From: Anna Gillings [REDACTED]
Sent: 15 November 2021 07:58
To: Anita Gardner <Anita.Gardner@arun.gov.uk>
Cc: Emma Patchell [REDACTED]
Subject: Dappers Lane - 2010/21/DOC

For completeness, please find attached the Offsite Drainage Works drawing which we understand is required for condition 16 of application ref. 210/21/DOC

TYPICAL BRICKWORK HEADWALL

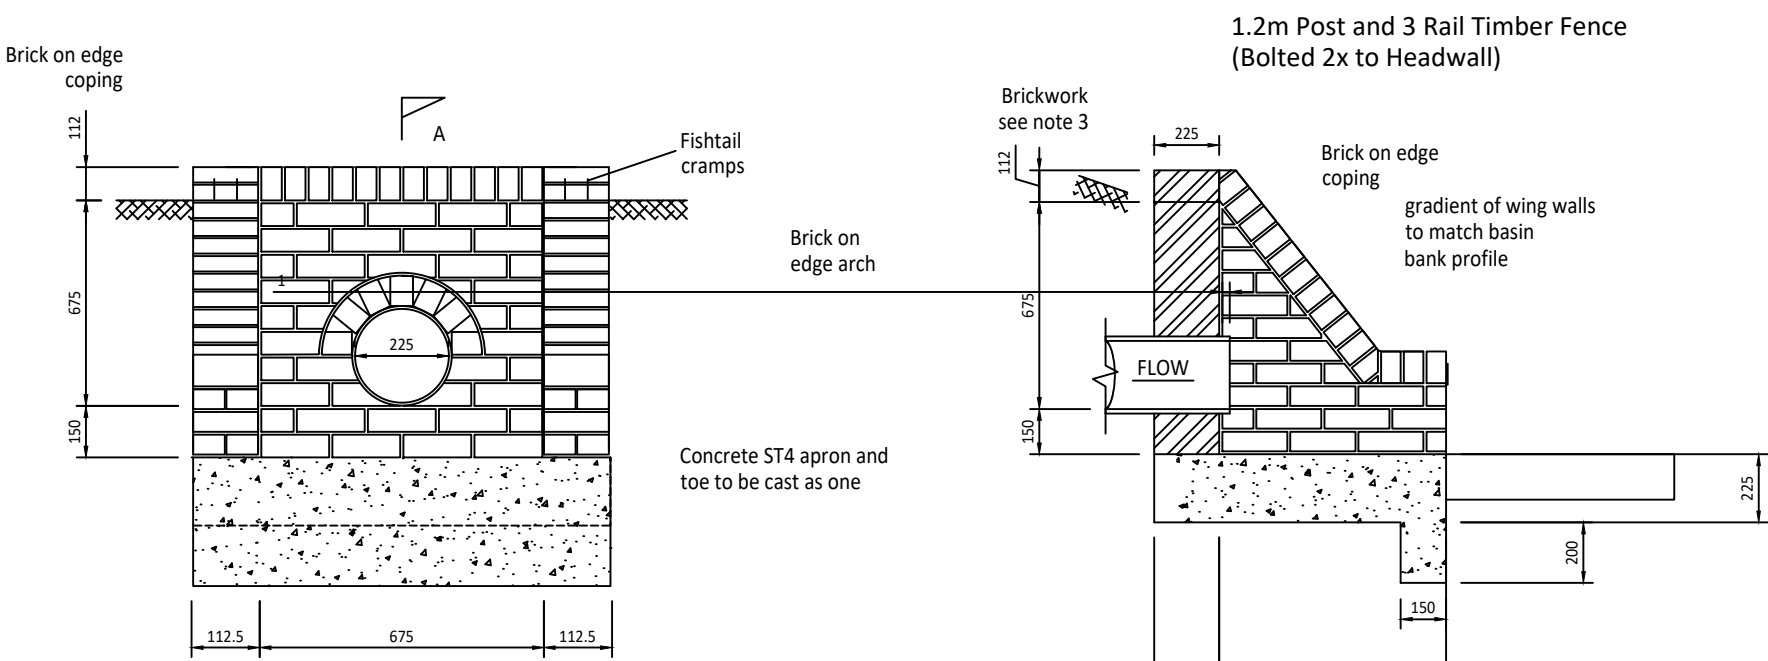
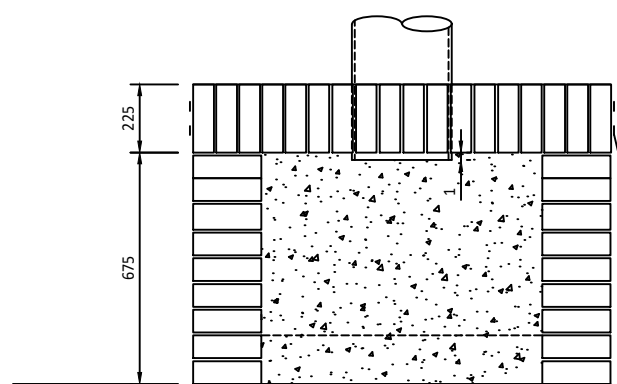
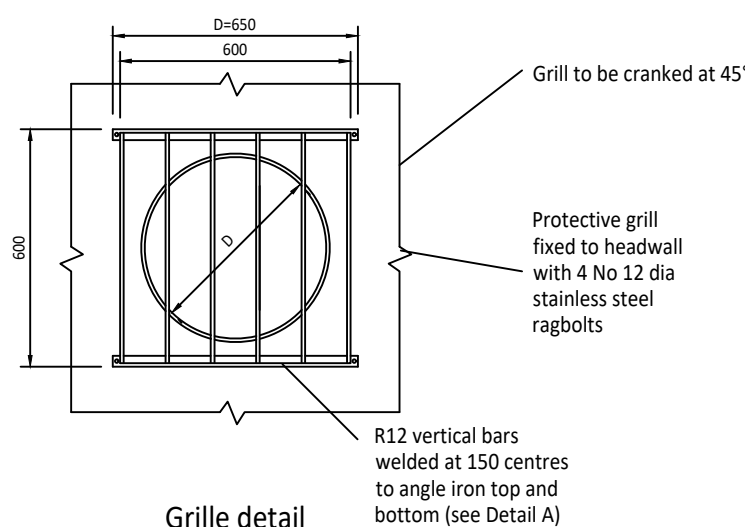
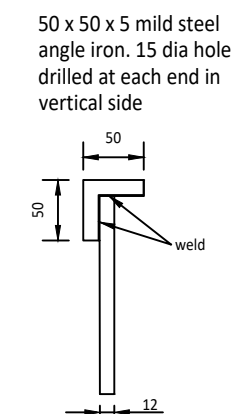
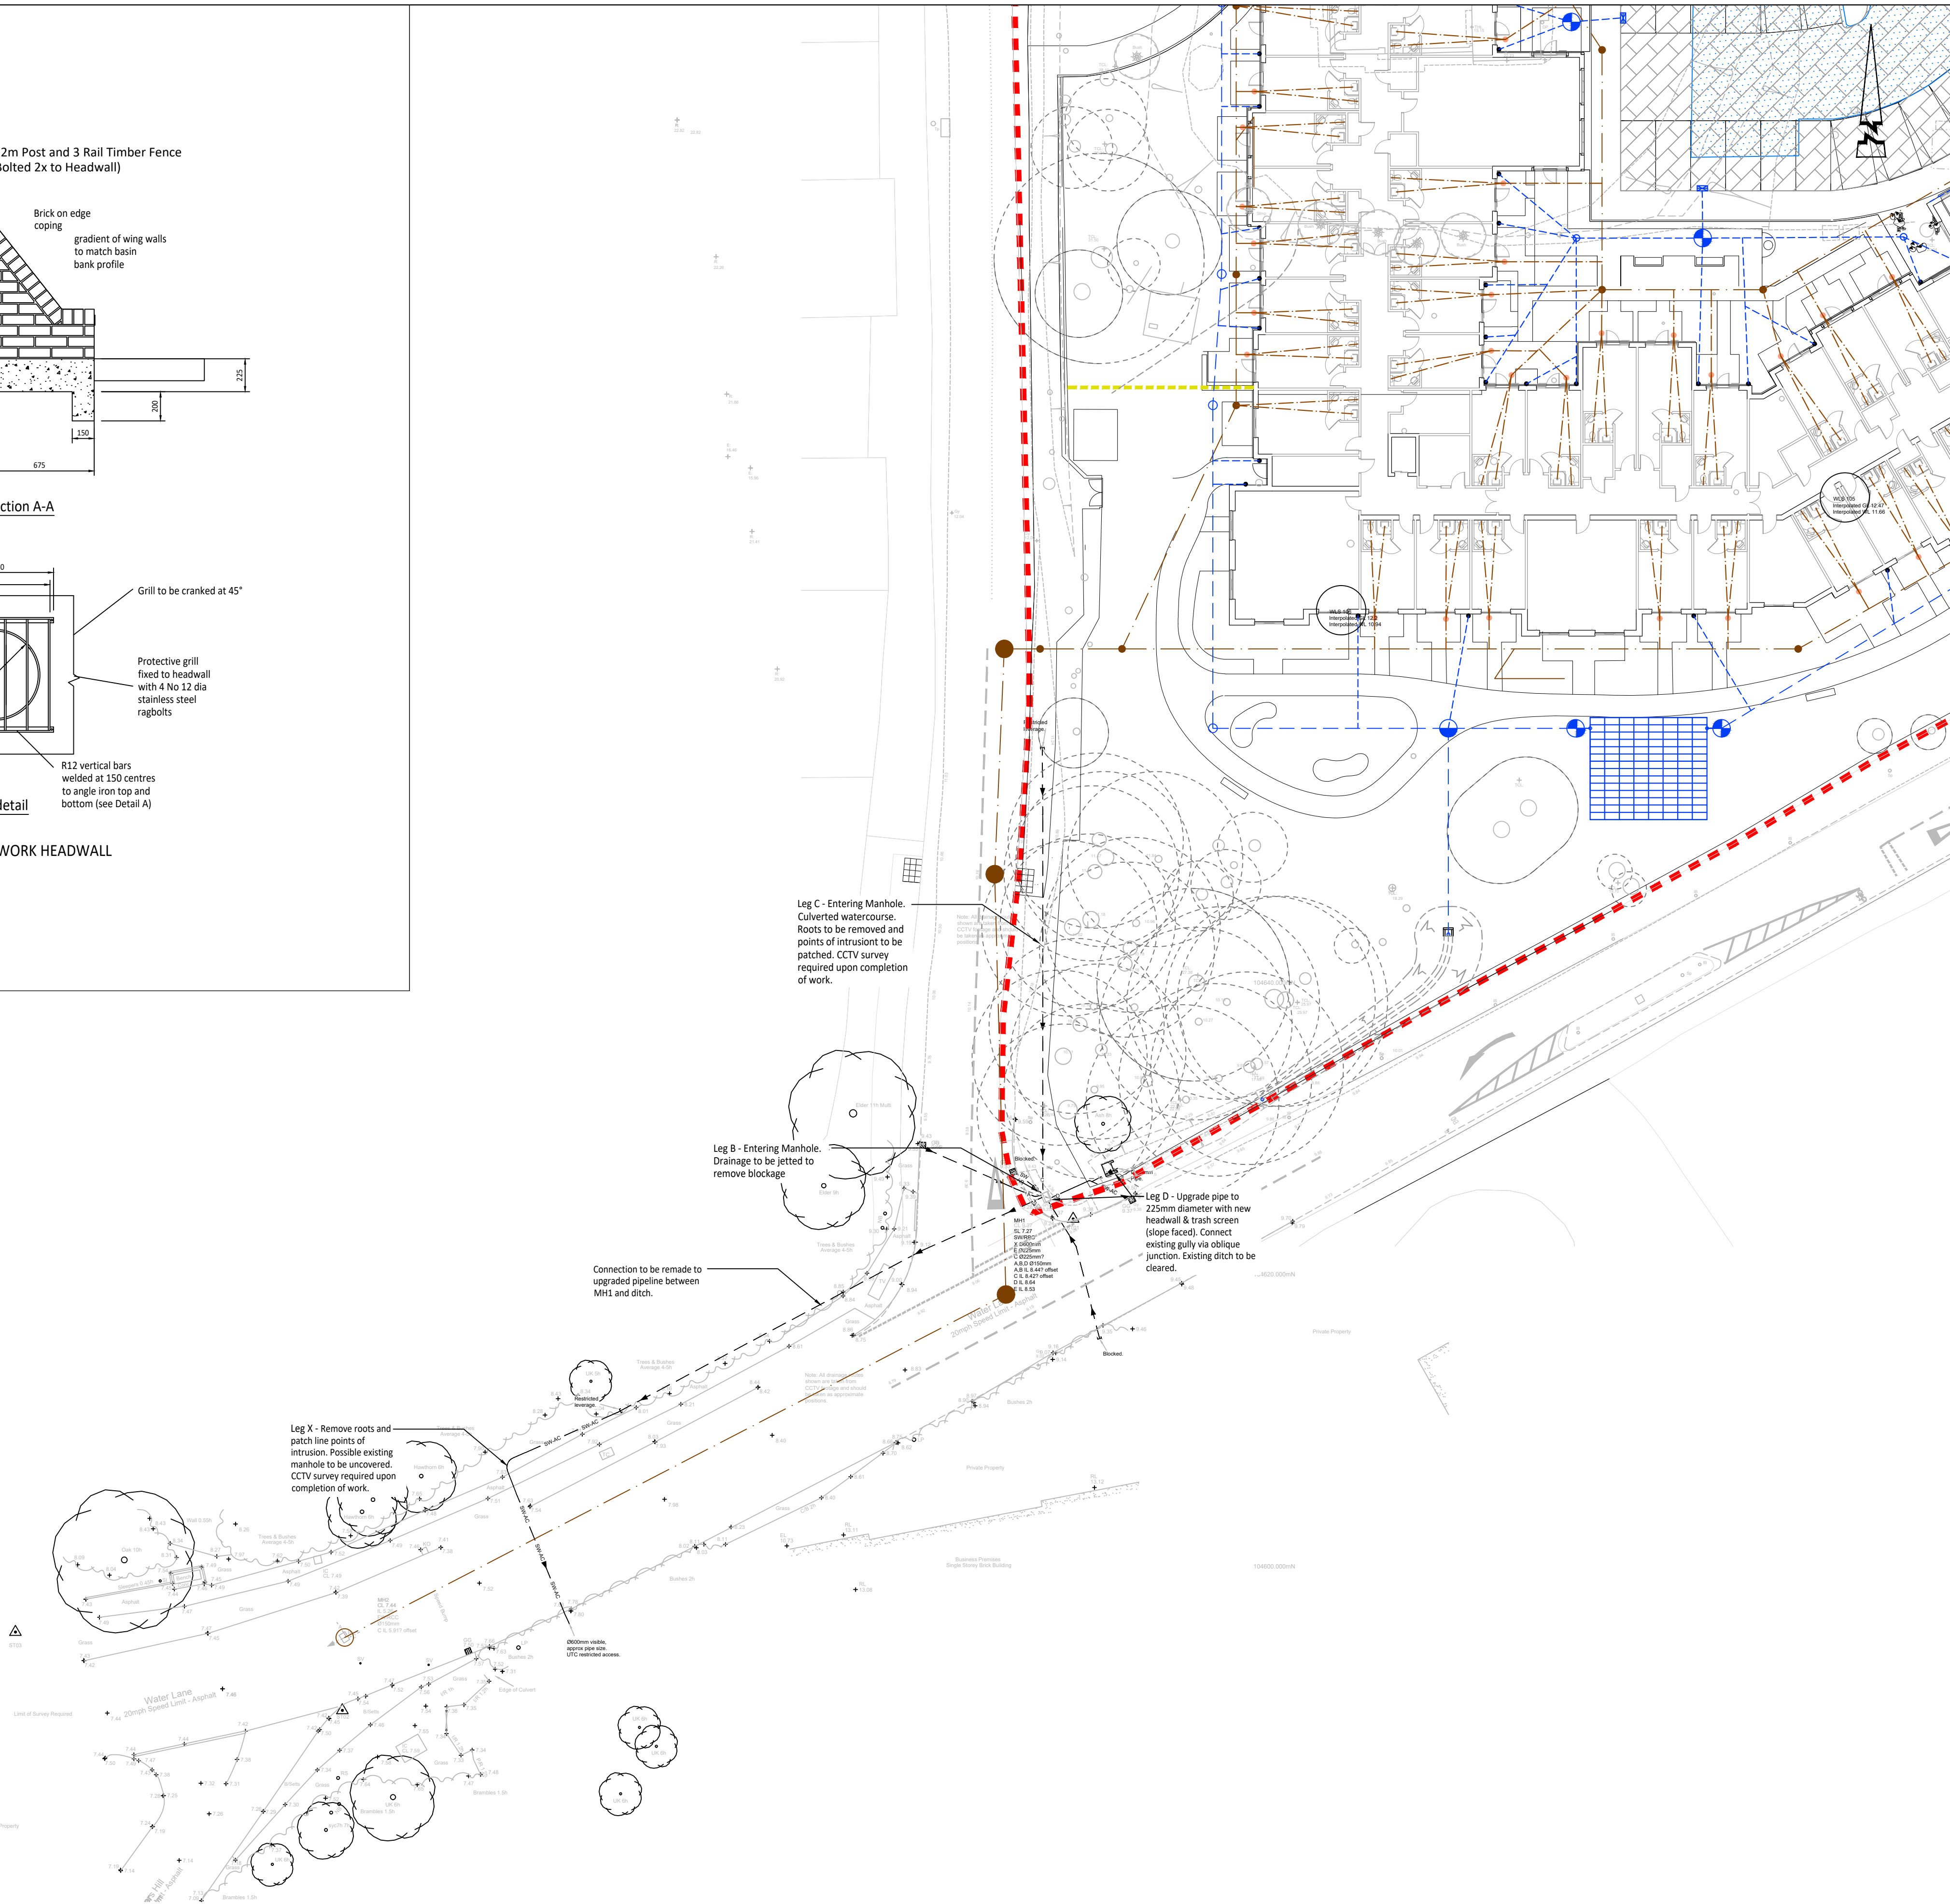
What we need to agree is offsite works to ensure the piped system downstream is fit for purpose to receive flows from the site, so I have copied in WSCC so we can have discussion internally and come back to you. Certainly the ditch itself will need cleaning out and from what I recall there is no headwall on the ditch outlet (so one will be required).

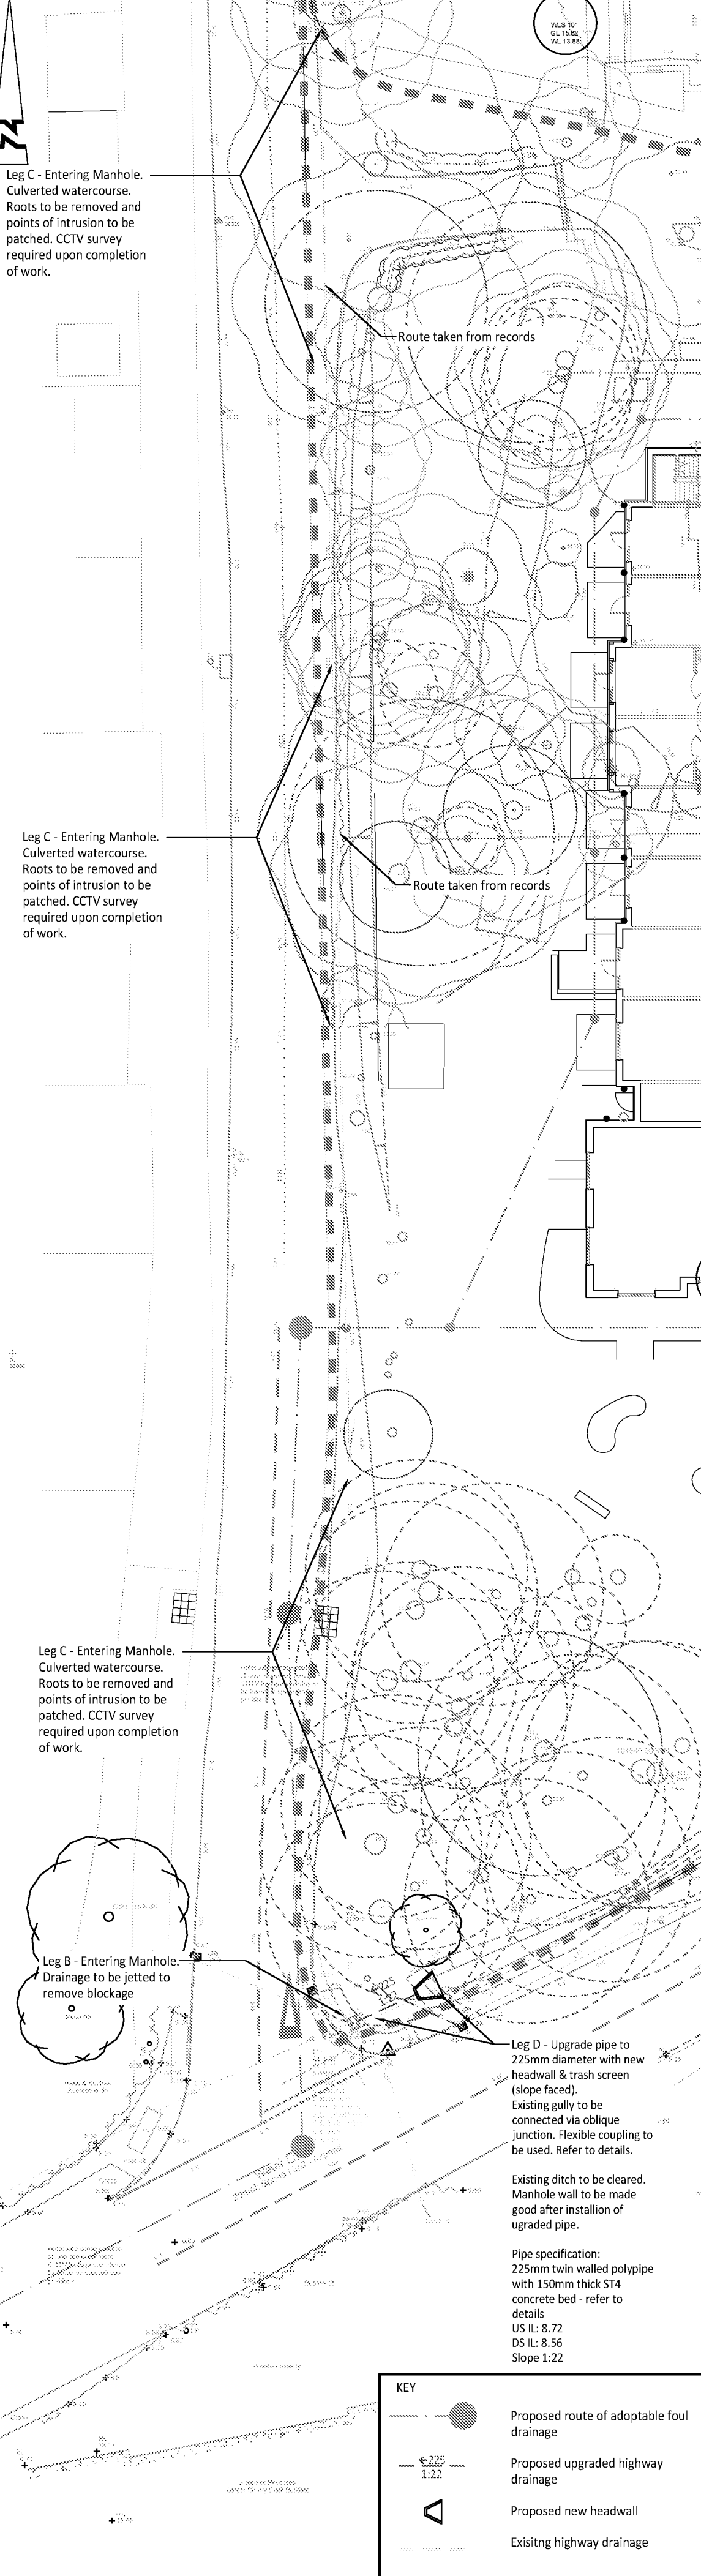
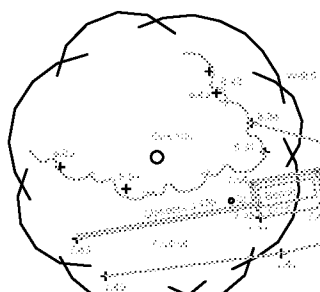
Pipeline Surveyed	Diameter (mm)	Issues	Remediation required	Comments
MH1 to Gully (Leg A)	150	Medium displaced joint @7.3m.	No action	WSCC responsibility
MH1 to Gully (Leg B)	150	Blocked.	Jetting to clear blockage (silt/roots?). CCTV afterwards to check for other issues/possible further works.	WSCC responsibility but if you have a jet machine on site to resolve the other issues listed below, clearing the blockage would be appreciated and this would also help reduce flood risk/safety (icing) concerns at the junction and benefit all concerned.
MH1 (Leg C)	225?	Medium displaced joint @12.2m. Root intrusion.	Remove roots.	Culverted watercourse. Adjoining landowner has riparian responsibility (ie. developer). Remove roots and patch line points of intrusion. Post CCTV survey required.
MH1 to ditch (Leg D)	150	Blocked.	Replace pipework.	Upgrade pipe to 225mm diameter with new headwall & trash screen (slope faced). Connect existing gully via oblique junction. Ditch to be cleaned out.

MH1 (Leg E)	225	Blocked/Badly fractured/siltation, etc.	No action.	Purpose of pipe unknown.
MH1 to Black Ditch (Leg X)	600	Root intrusion.	Remove roots.	Remove roots and patch line points of intrusion. Post CCTV survey required. Entire pipeline to the Black Ditch needs to be CCTV surveyed. A buried manhole possibly exists. Further discussion can be had once more is known.

Pipe 1 to MH1 (assumed to be gully connection immediately downstream of ditch outlet)	150	Medium displaced joint @0.6m.	Remake connection.	Connection to be remade to upgraded pipeline between MH1 and ditch.
--	-----	----------------------------------	--------------------	---
